A/6/20/L

Listed building consent for the re-roofing & upgrading of entire roof; repointing existing brickwork & replace cracked, unventilated chimney pot with new clay; works to fascia & guttering; replace lead roof over bay window; flashing to existing bathroom; installation of timber stud firewall in loft space along party wall & repoint brick work & fling walling as required

ROOF PLAN 1: 50

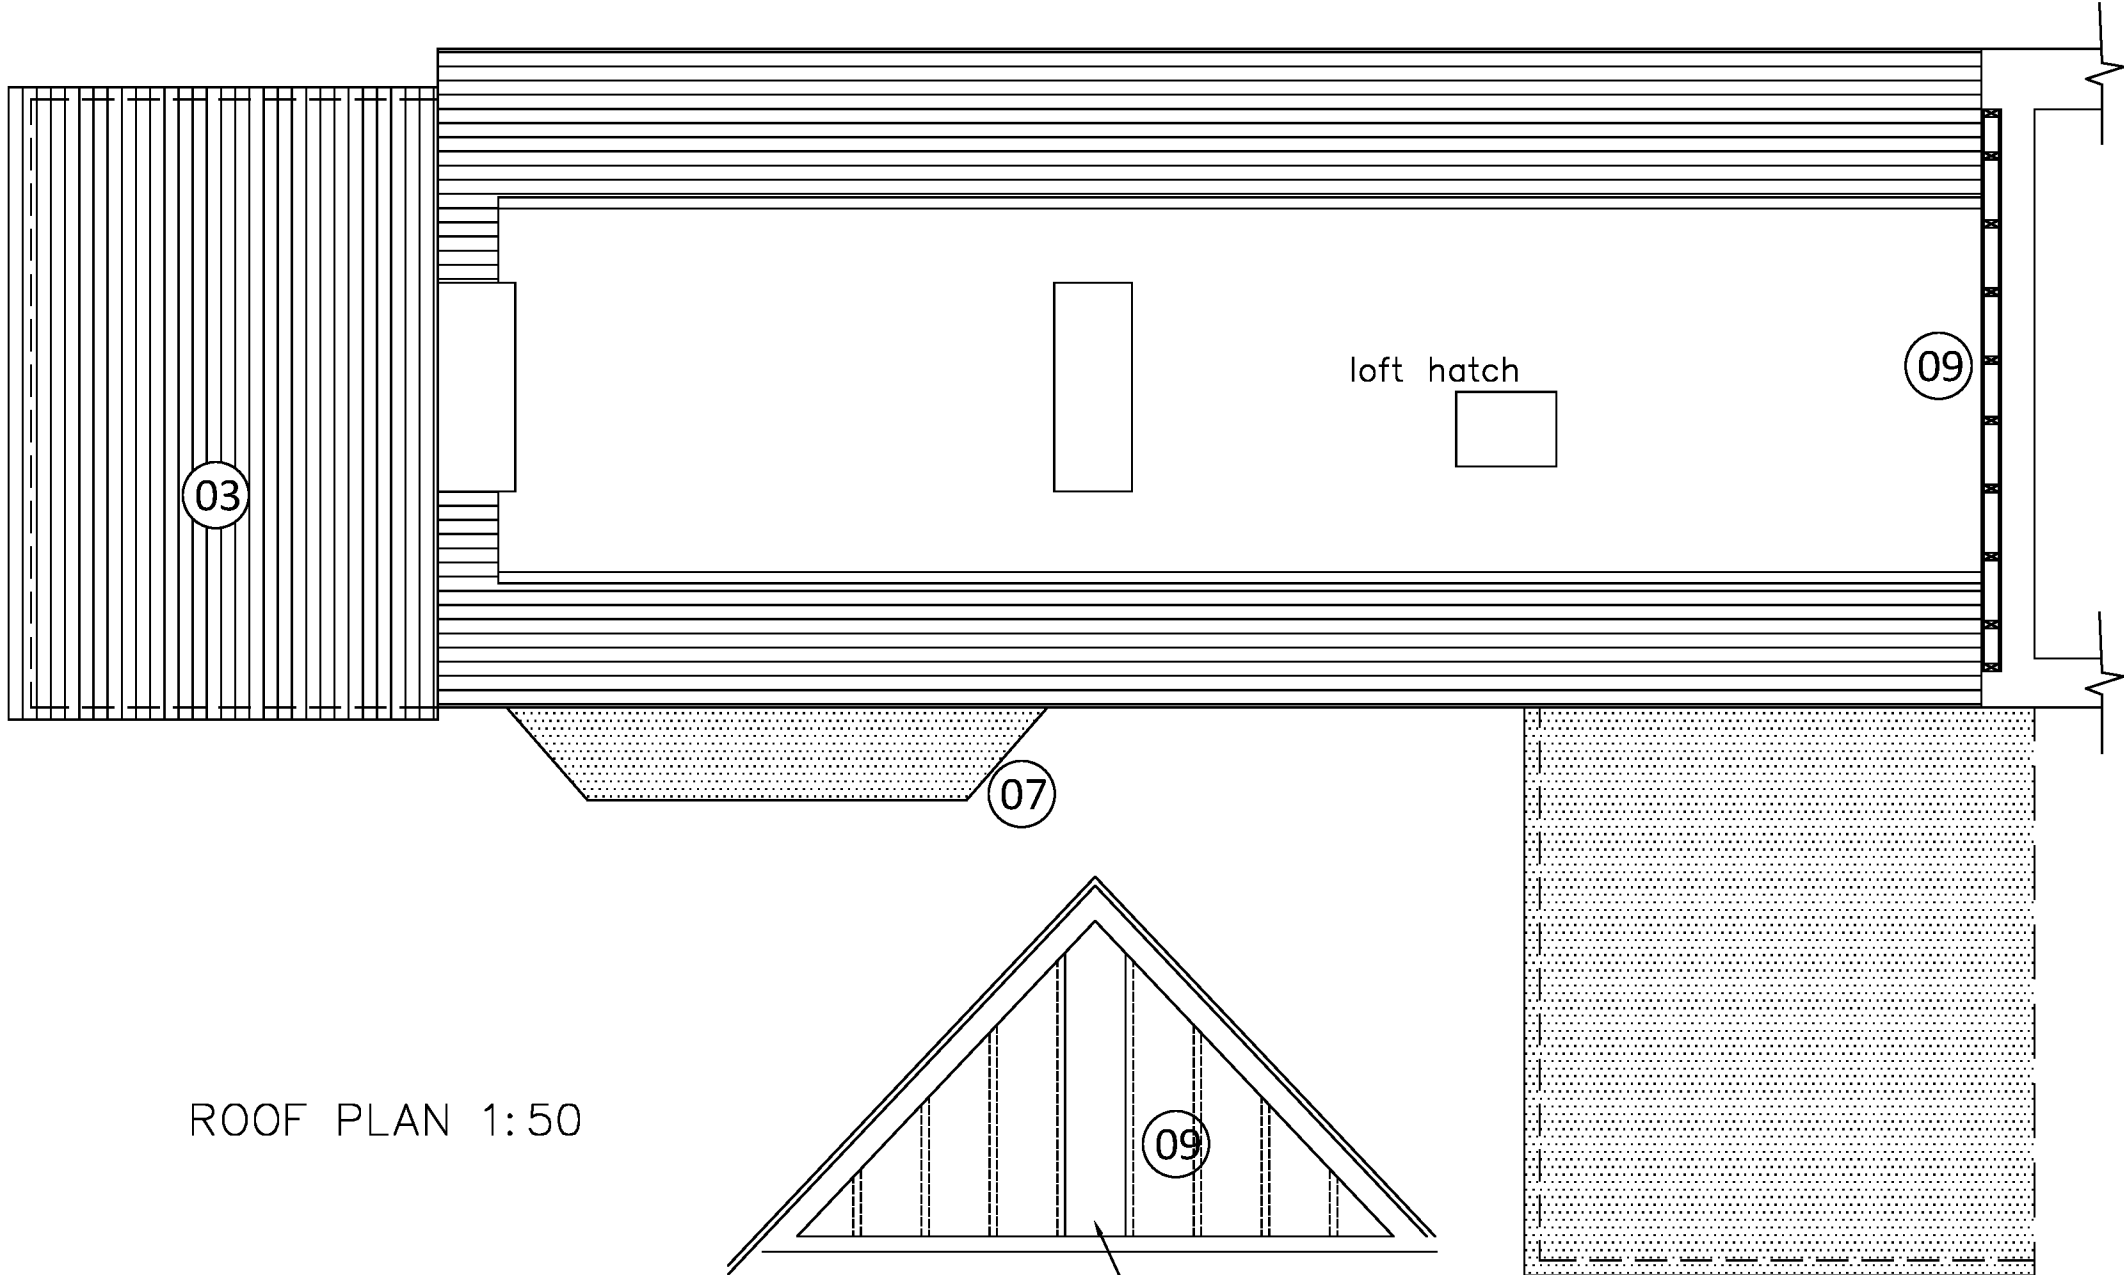
The proposal is for various works of repair to the tiled roof as well as a bay window roof and other lead flashing. It also requests consent for a timber stud firewall in the loft space and works of repointing on part of the southern gable wall. Having had the opportunity to review the information submitted as part of the consent, it is considered that they appear to be acceptable and do not harm the significance of the listed building. All materials should match existing, and you may wish to require samples to be provided if minded to approve the application. Likewise, the pointing should match the existing in terms of materials, appearance, colour and texture.

REAR ELEVATION 1:100 EAST

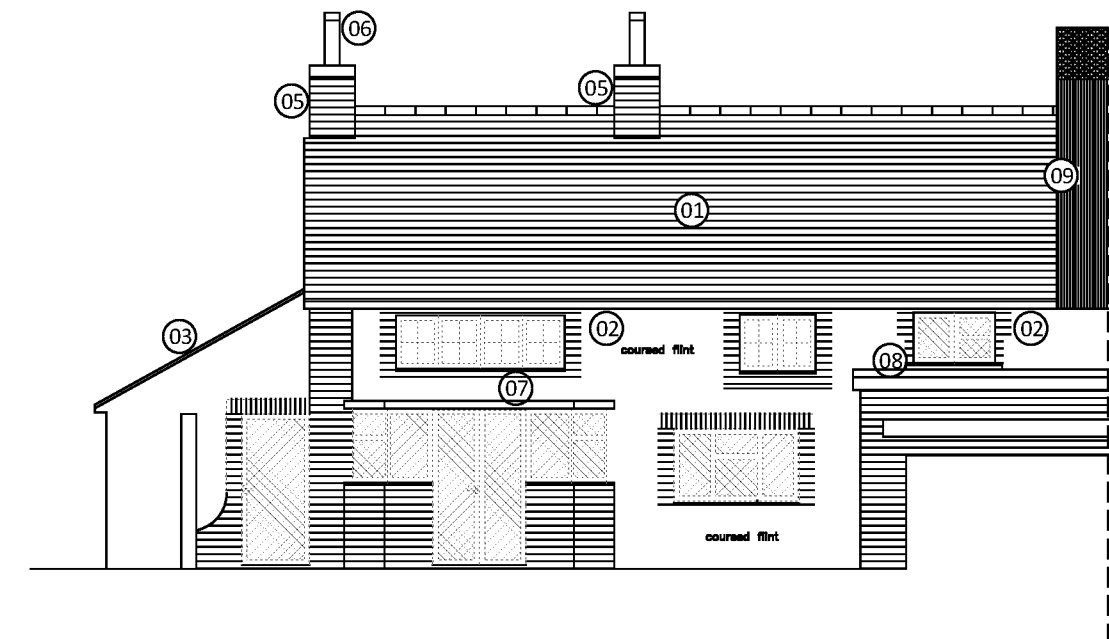
It would appear that the existing bathroom window is UPVC and not appropriate for a listed building. It is not clear if the relevant consent has been sought for this. However, it is considered that the listed building consent provides the opportunity to replace this inappropriate window with something more in keeping with a listed building.
